Document ref: SAL-COR-C-ARUN-0002

SALT BOX FIELD LAND OFF ROWAN WAY BOGNOR REGIS

Planning ref: BE/135/18

To assist in your review of the information to discharge the drainage planning conditions under the new application for Unit 2 and Estate Road **BE/135/18**. We have put together a summary of the revisions to the drawings issued for Conditions 9 and 10 under the previous planning application **BE/102/17**.

DRAWING NO.
SAL-HYD-PH1-ZZ-DR-C-7010

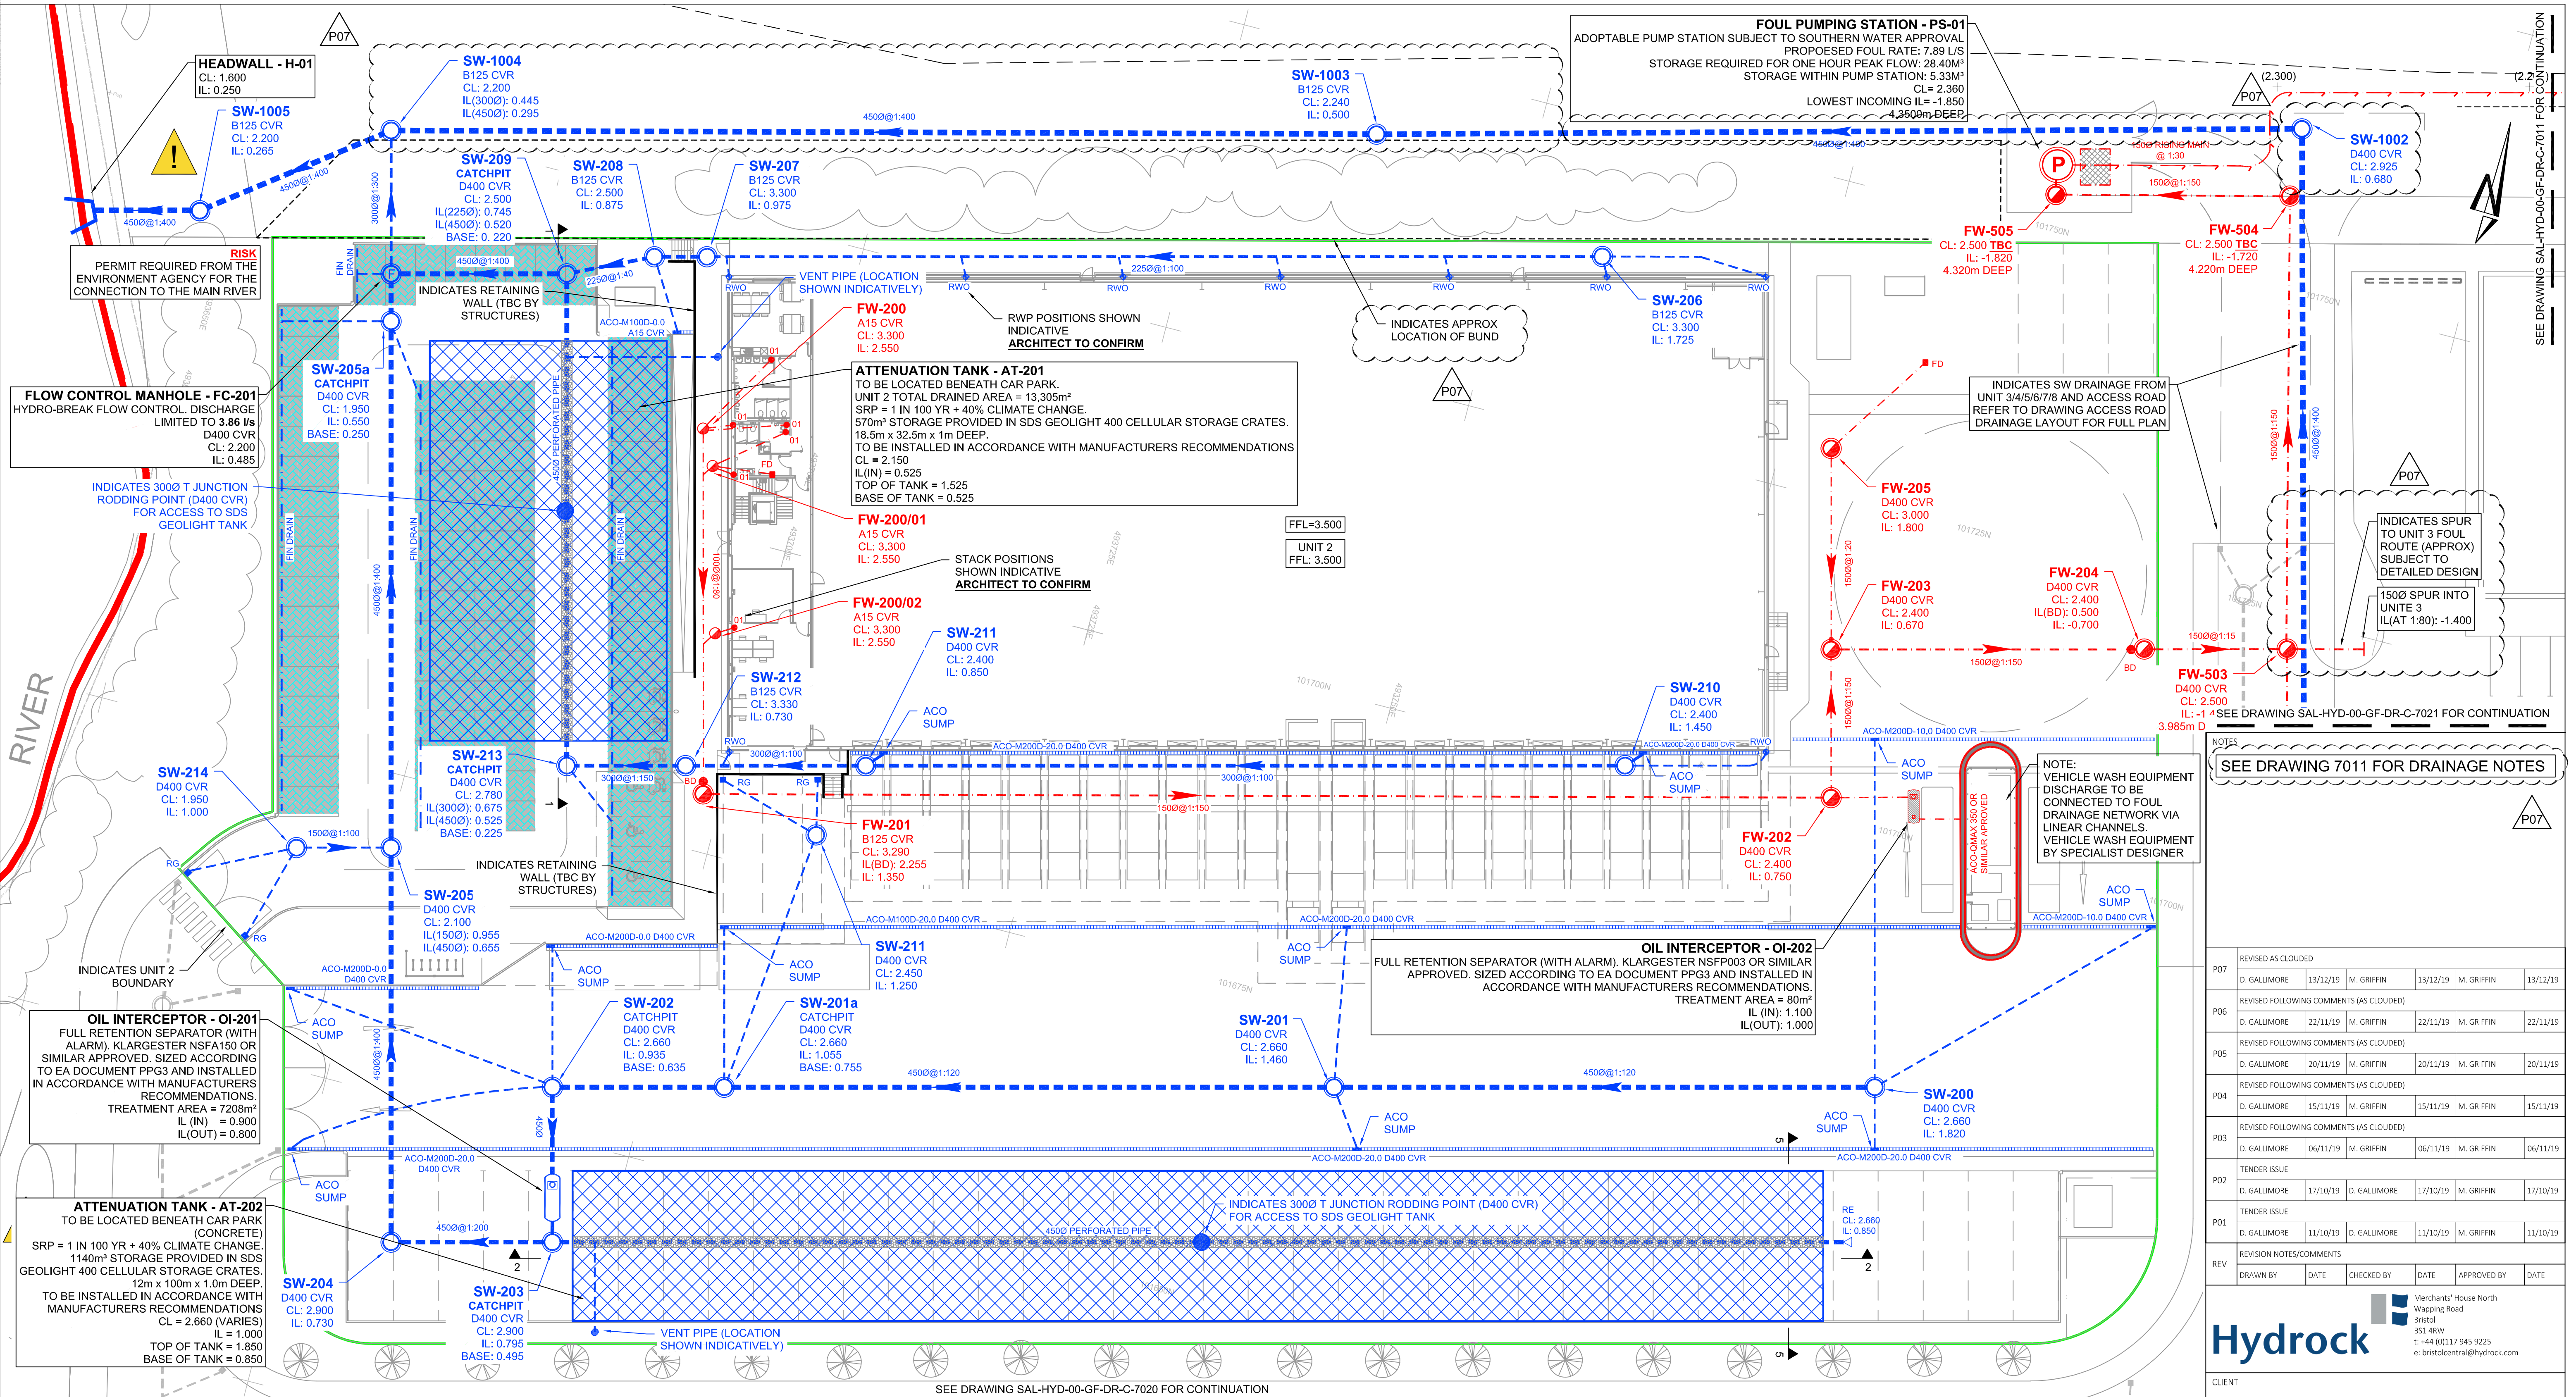
Previous Application: Conditions 9 and 10	New Application: Conditions 12, 13, 14 and 16
Old Drawing: SAL-HYD-00-ZZ-DR-C-7010 Rev P06 Updates: - SW pipe north of the site moved to avoid proposed site bund - Foul drainage spurs and levels added for adjacent sites	New Drawing: SAL-HYD-PH1-ZZ-DR-C-7010 Rev P07
N/A Updates: - New drawing showing the foul drainage from pump station connecting to off-site manhole	New Drawing: SAL-HYD-PH1-ZZ-DR-C-7011 Rev P01
Old Drawing: SAL-HYD-00-ZZ-DR-C-7020 Rev P09 Updates: - Access road impermeable areas changed to allow 20% permeability in the grass verges - Drainage amended to suit new levels - FPMccann concrete culvert removed to be replaced by the Carlow concrete culvert - Culvert volume amended following change of areas (now 845m3 required) - Length of culvert reduced following area change	New Drawing: SAL-HYD-PH1-ZZ-DR-C-7020 Rev P10
Old Drawing: SAL-HYD-00-ZZ-DR-C-7021 Rev P07 Updates: - As 7020 updates	New Drawing: SAL-HYD-PH1-ZZ-DR-C-7021 Rev P08
